re: **Addendum to Landslide Hazard Assessment Report**
Proposed Multi-Storey Building Complex
1009 Trim Road – Ottawa, Ontario
to: Vuze Construction – **Martin Chénier** – chenierm@live.ca
date: June 2, 2026
file: PG5336-MEMO.11

Technical Review Comments and Report Addendums

The following comments have been posed by the City of Ottawa in their technical review of the Geotechnical Report and aforementioned Landslide Hazard Assessment Addendum report. The responses are being prepared by Paterson and are considered addendums to the aforementioned Landslide Hazard Assessment report dated July 6, 2023.

AP-10

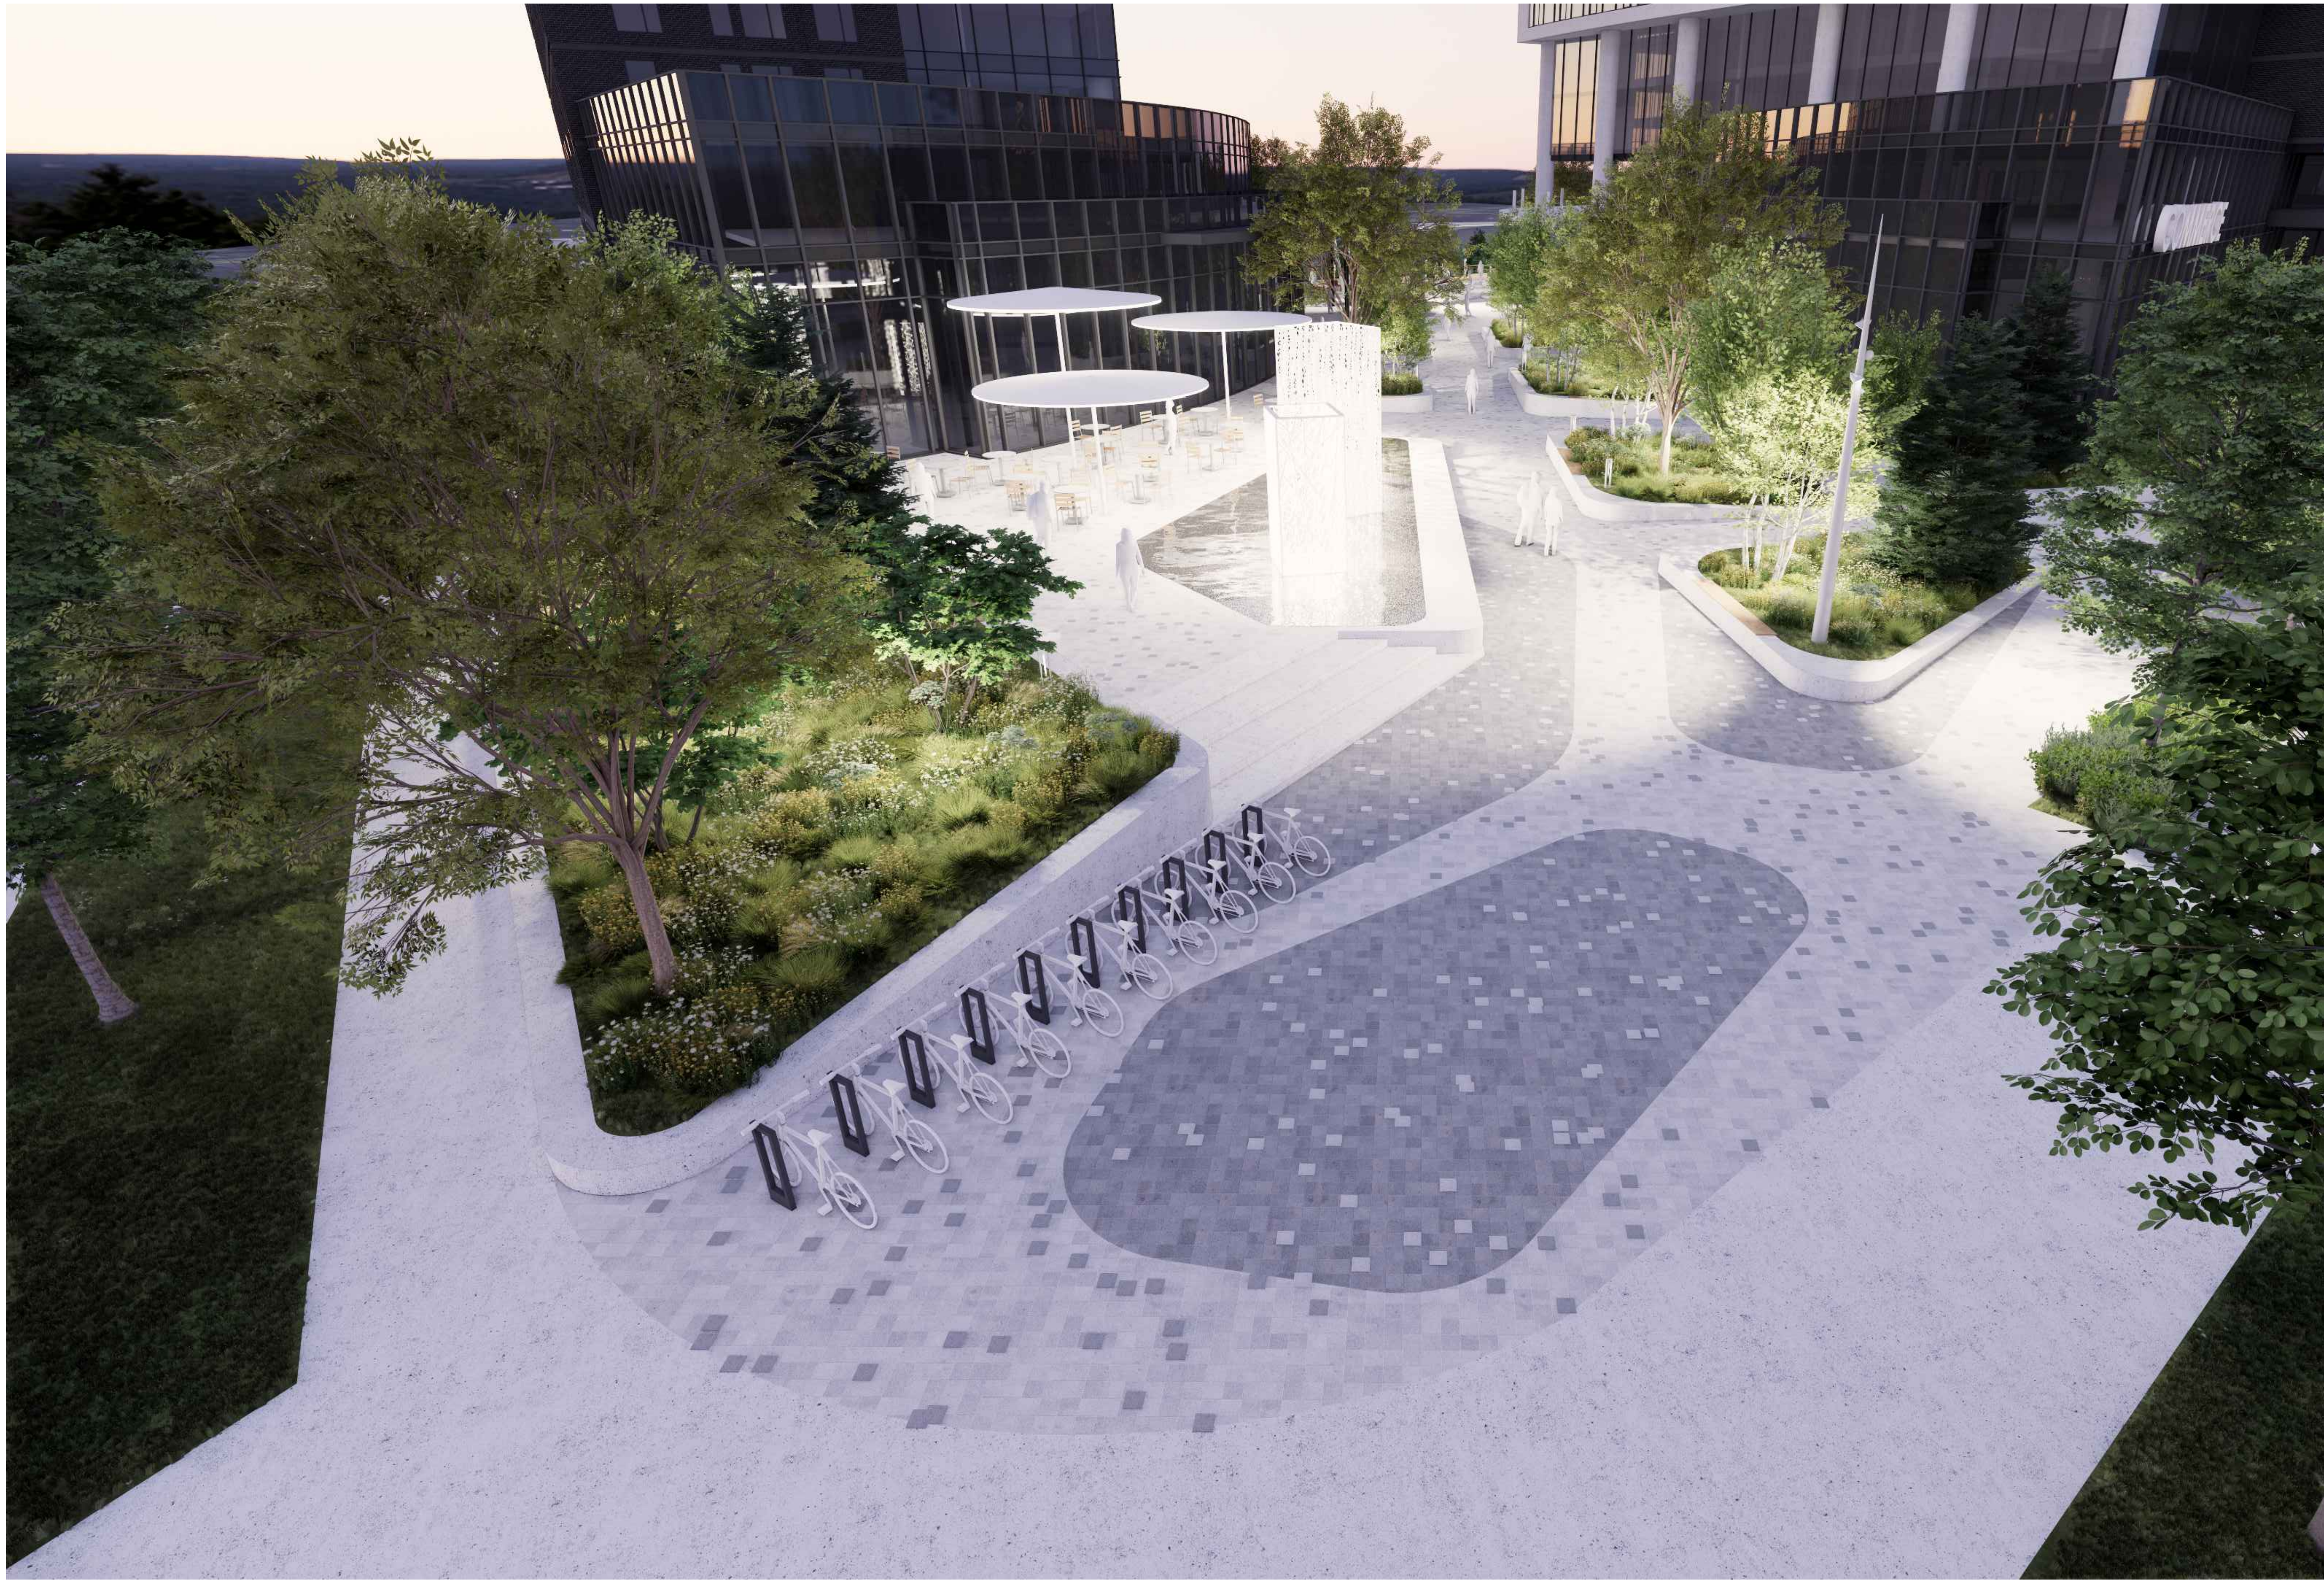
Comment 2: *The addendum recommends consultation with a river process expert to determine appropriate erosion protection measures. This study should be submitted for City review.*

Based on Paterson's review of the currently proposed landscape architecture plans prepared by Project Paysage, the majority of the proposed seedings within the floodline zone mix (i.e., Mix 1 noted on Landscape Plan Sheet No.: AP-10 dated March 2025) consists of tall grasses as are present in the existing condition. Establishing this type of vegetation, which is expected to perform adequately in occasionally submerged and marshy conditions, will continue to provide an equivalent amount of protection against active erosion in the post-development condition as exists in the current condition.

It is a requirement that all earth fill and grading undertaken in the sloped area be undertaken as described in Section 5.2 of the Geotechnical Report to ensure the earth fill is placed in a manner to resist erosional forces. Compacting and placement of appropriate fill will provide adequately durable soils to protect the underlying native soils from on-going erosion. At later stages of the project (i.e., in the near post-development stage) the slope will be covered with the aforementioned landscaping design which will serve to protect the slope area from active erosion and fluctuations in the Ottawa River levels.

Based on this, while a dedicated assessment of river action has not been undertaken for the subject site, the subject portion of the Ottawa River behaves more like a wetland than an active stream within a confined valley with high erosional forces. Since the changes in the water levels are not resulting in active erosion, the review of the waters impact on the stability of the subject slopes is considered geotechnical and is able to be assessed from this perspective for landslide susceptibility purposes. Provided the measures noted in the geotechnical report are taken during the earthwork's stages along the slope, landscaping is undertaken as noted in the landscaping drawings and establishes adequately, this recommendation is considered to be satisfactorily incorporated in the proposed design to satisfy the ALARP condition advised in the previous Landslide Hazard Assessment report.
